Title: **Proposed Strategic Housing Development At Ballymany
Combined Stage 1&2 Road Safety Audit**

Client: **Briargate Developments Newbridge Limited/Muir
Associates**

Date: **May 2021**

Report reference: **1035R01**

PROJECT	STRATEGIC HOUSING DEVELOPMENT AT BALLYMANY		
CLIENT	BRIARGATE DEVELOPMENTS NEWBRIDGE LIMITED		
TITLE	ROADS LAYOUT		
	SHEET 1 of 4		
Director SOR	Proj. Eng. SS	Drawn by SC	DRG. No. D1920-MAL-00-XX-C-002
Scale 1:500 @A1	Checked SOR	Date MARCH 21	REV C

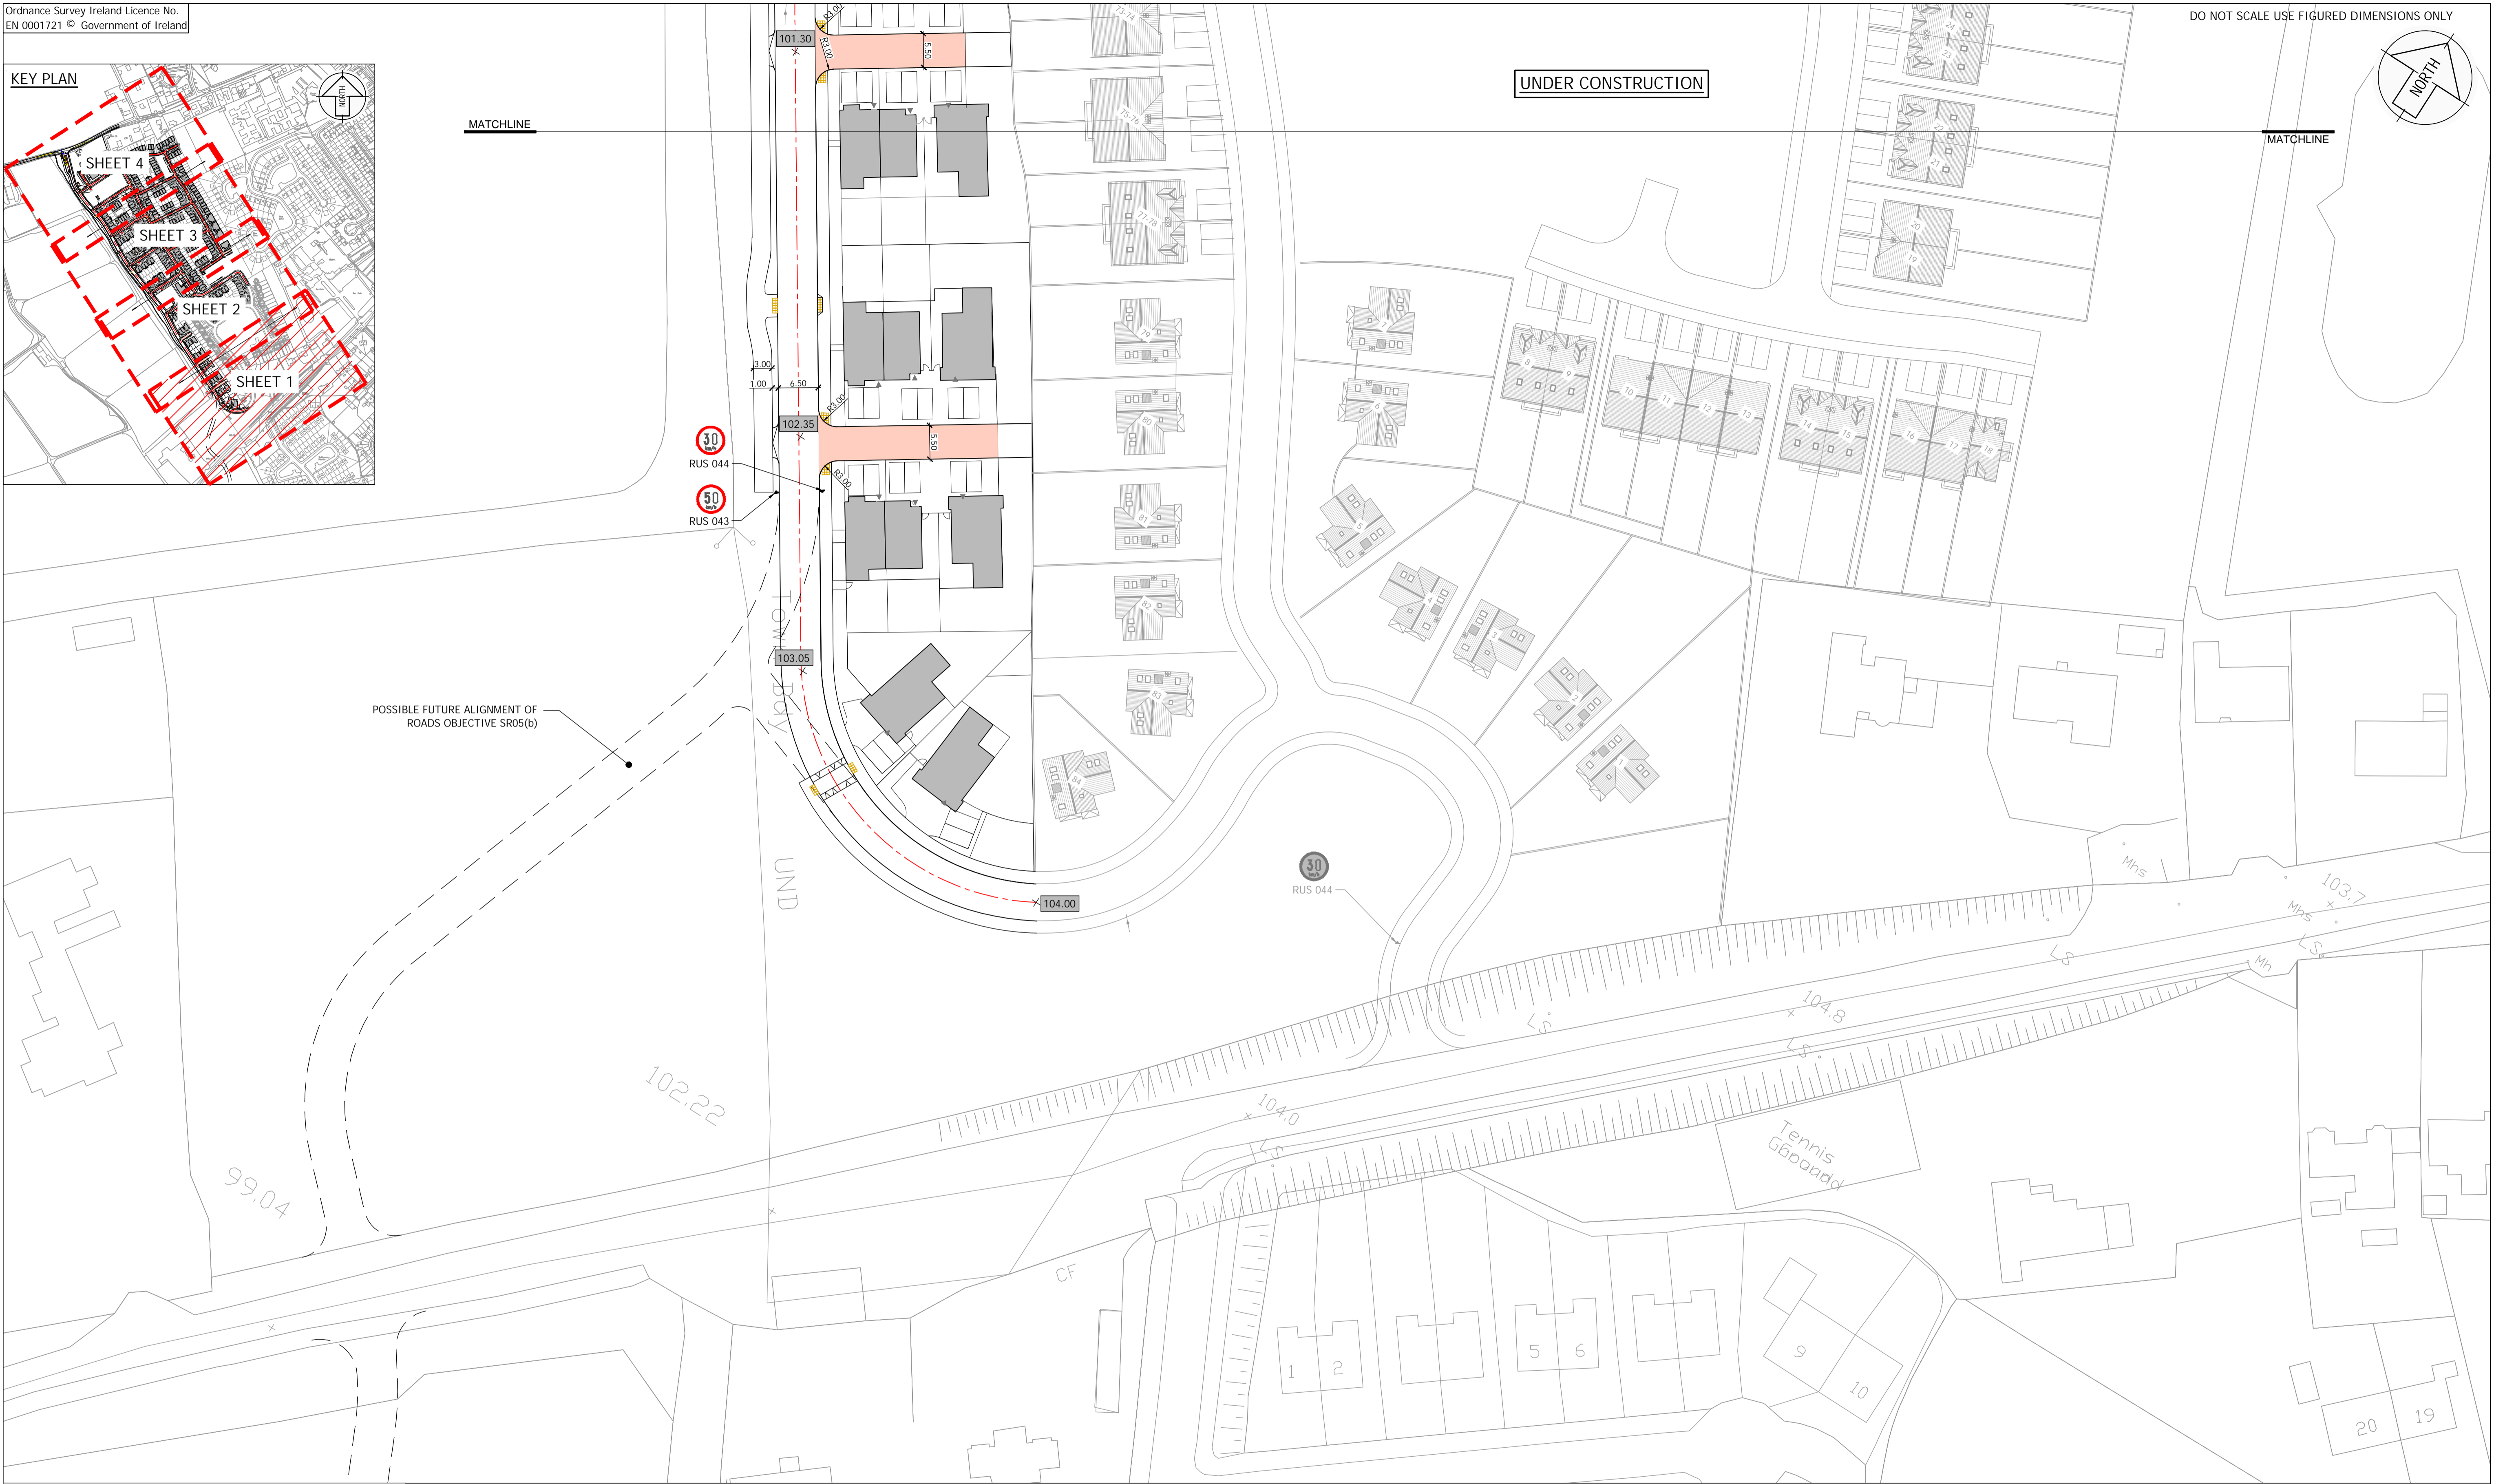
Drawing D1920-MAL-00-XX-C-002 Rev B, 003 Rev A, 004 Rev A & 005 Rev A, Overall main access road.

The main access road is relatively long. This could lead to high speeds and result in high injury severity if a vulnerable road user (e.g. a cyclists accessing the segregated cycle track) is struck by an errant vehicle.

It is recommended that traffic calming features be provided on the main link road of the development that will lead to speeds of 50km/hr or lower.

3.1	NO	NO	The Link Road is part of a previously permitted development on the site and forms part of the Newbridge LAP Roads Objective 05(b). The design of the horizontal and vertical alignments of the Link Road together with the frequency of junction spacing at designated intervals provides for a traffic calming effect. It is also worth noting that the part of the southern section of the Link Road is limited to 30 km/h and incorporates a raised pedestrian crossing in order to reinforce the traffic calming effect.	Yes

Drawing D1920-MAL-00-XX-C-002 Rev B, Visibility from driveway, most southern unit.

The most southerly unit is located on a sharp bend of the main access road. There is a risk that drivers exiting this premises may not have adequate visibility to approaching southbound vehicles. This could result in collisions.

It is recommended that suitable visibility be provided.

3.2	YES	YES	Note: An appropriate visibility splay for the Plots in question will be demonstrated as a part of the planning application drawings.	Yes
3.3	YES	YES

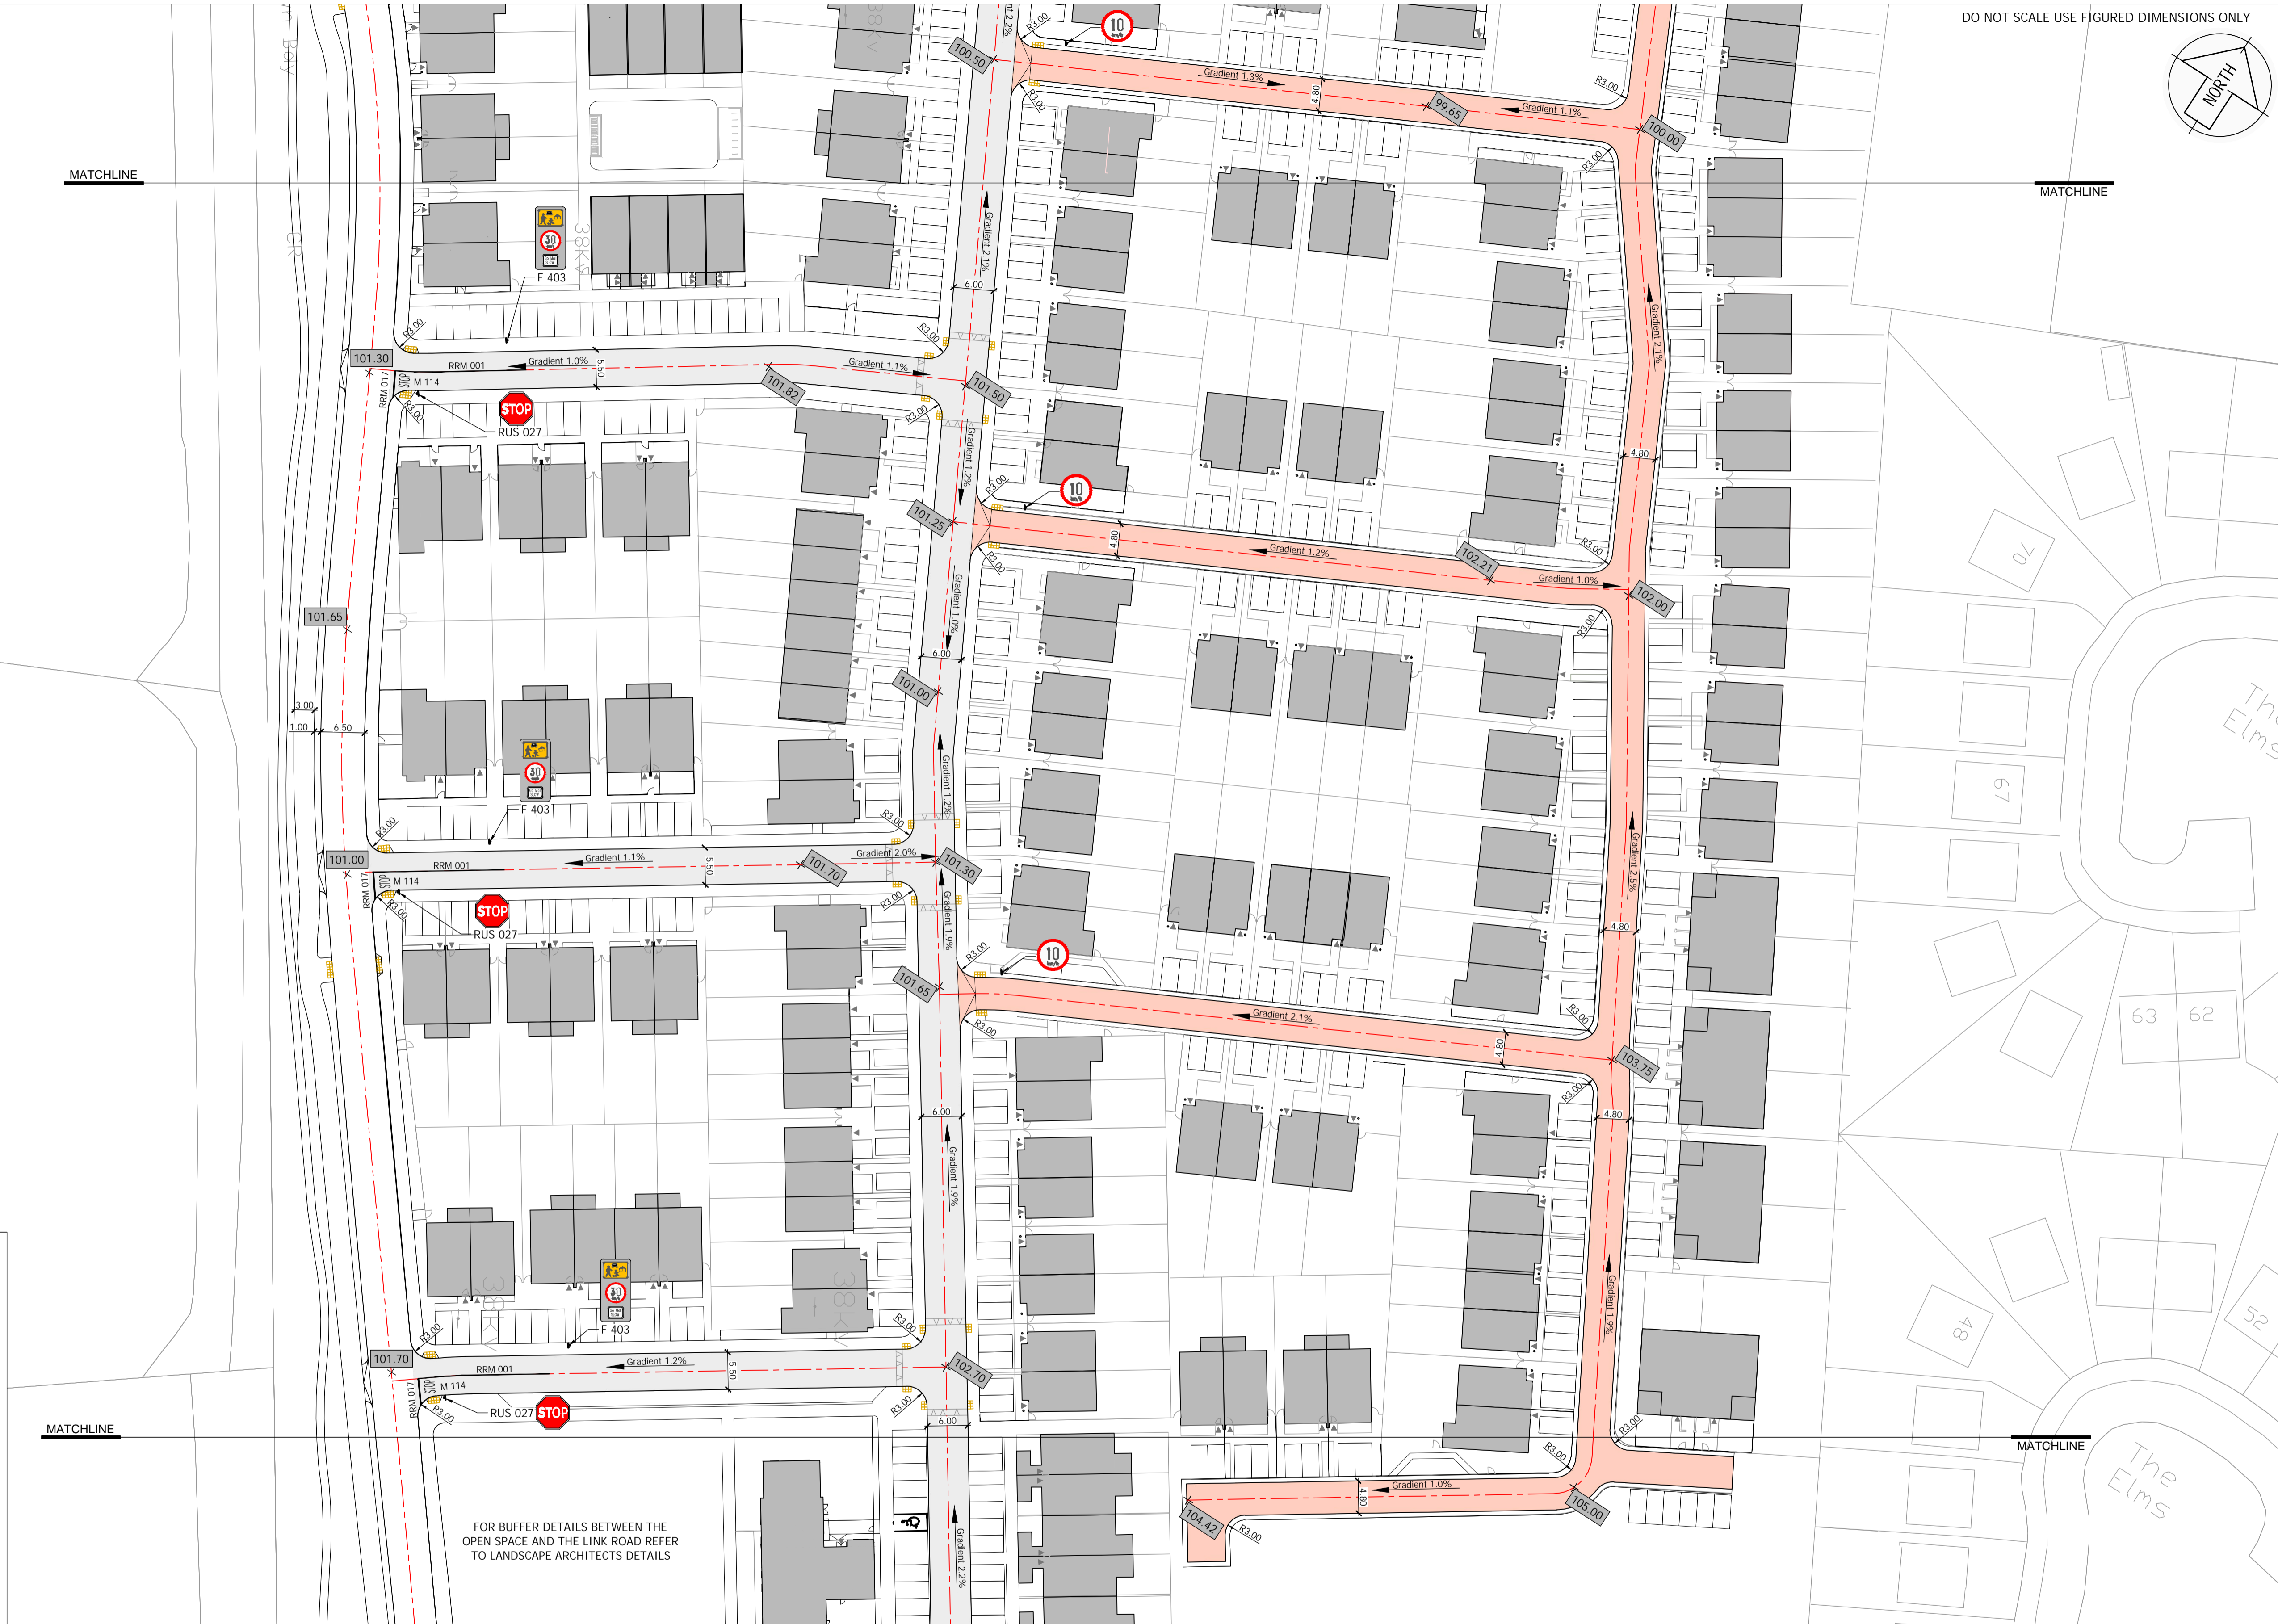
Drawing D1920-MAL-00-XX-C-002 Rev B, 003 Rev A, 004 Rev A & 005 Rev A, Trees within visibility splays.

Throughout the proposed development trees are shown at the internal junctions. There is a risk that these trees could obscure inter-visibility between drivers and pedestrians. This could lead to collisions.

Ensure trees do not block visibility splays.
